**From:** Michelle Boycott <[REDACTED]>  
**Sent:** 26 November 2020 17:29  
**To:** DC Support  
**Subject:** Application No.: 20/02956/F. Swalcliffe Park Equestrian

Further to your letter of the 13th November, 2020 concerning Planning Consultation of Planning Application No. 20/02956/F I would like to OBJECT on the proposed development for the following reasons:

DRAWING TITLE
 Application Site Boundary

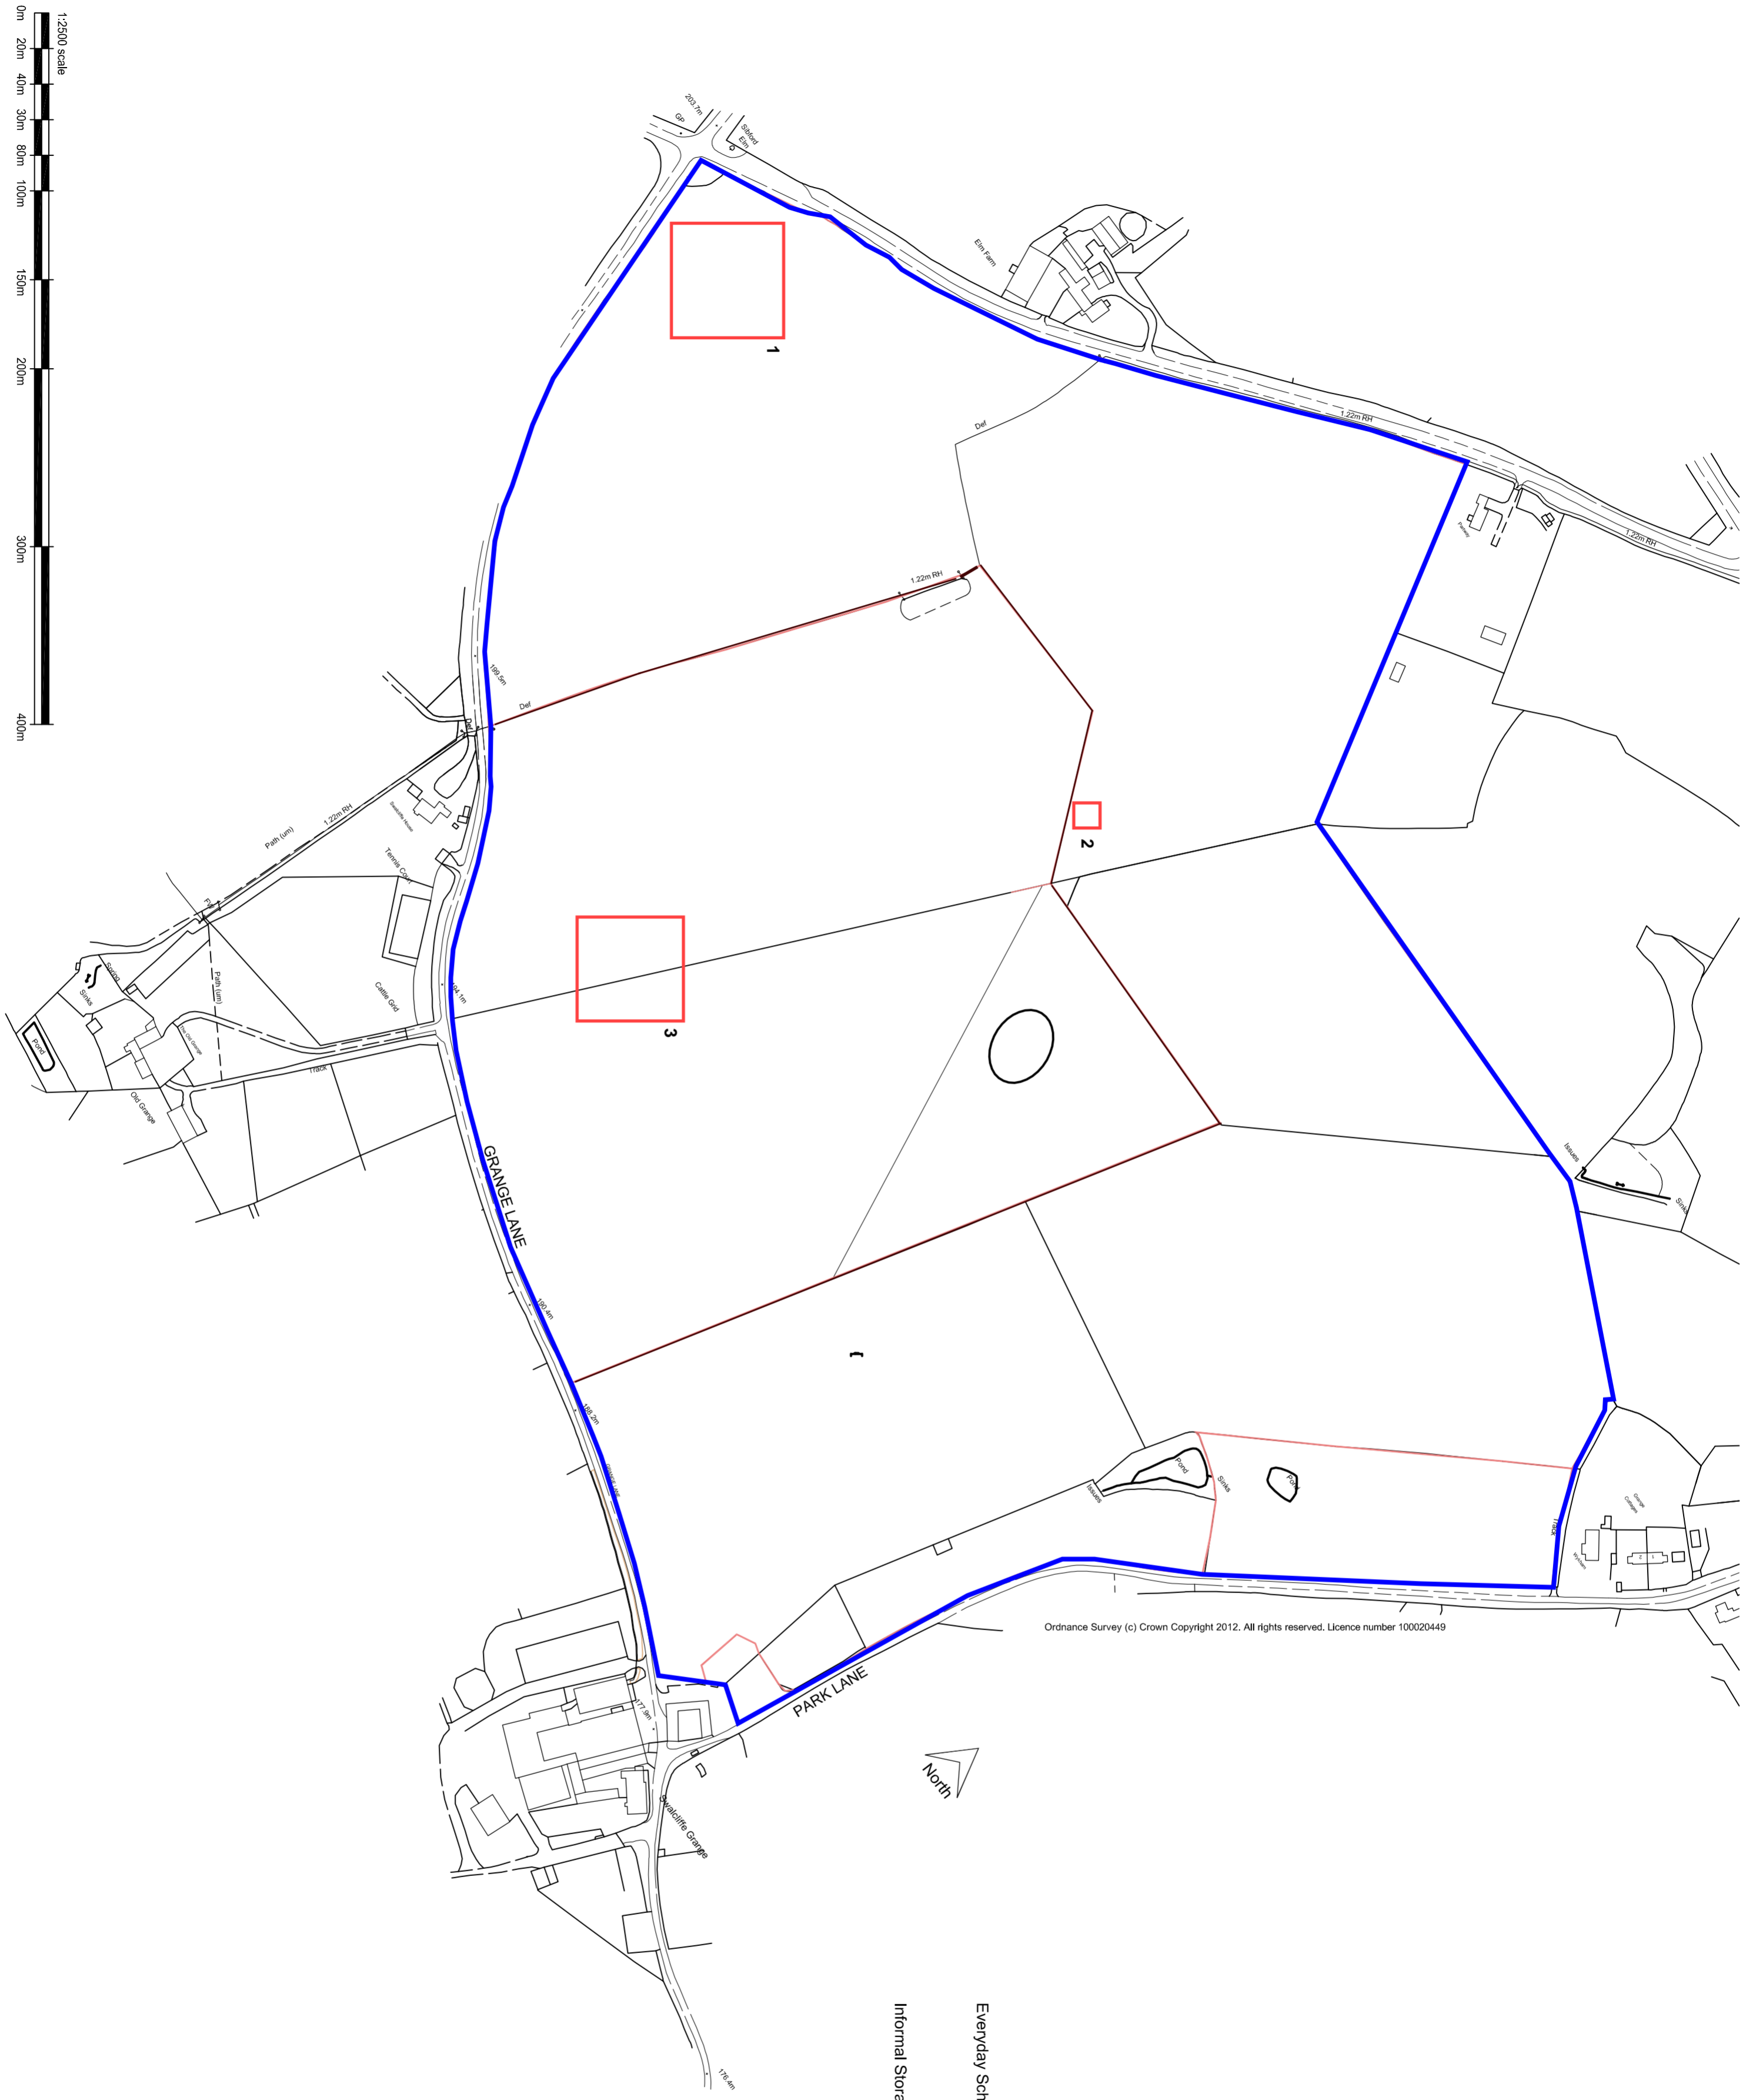
2. The Application is factually incorrect insofar as the site plan fails to recognise the scale/true location of the proposed development.

Therefore, SCALE DRAWINGS ARE REQUIRED.
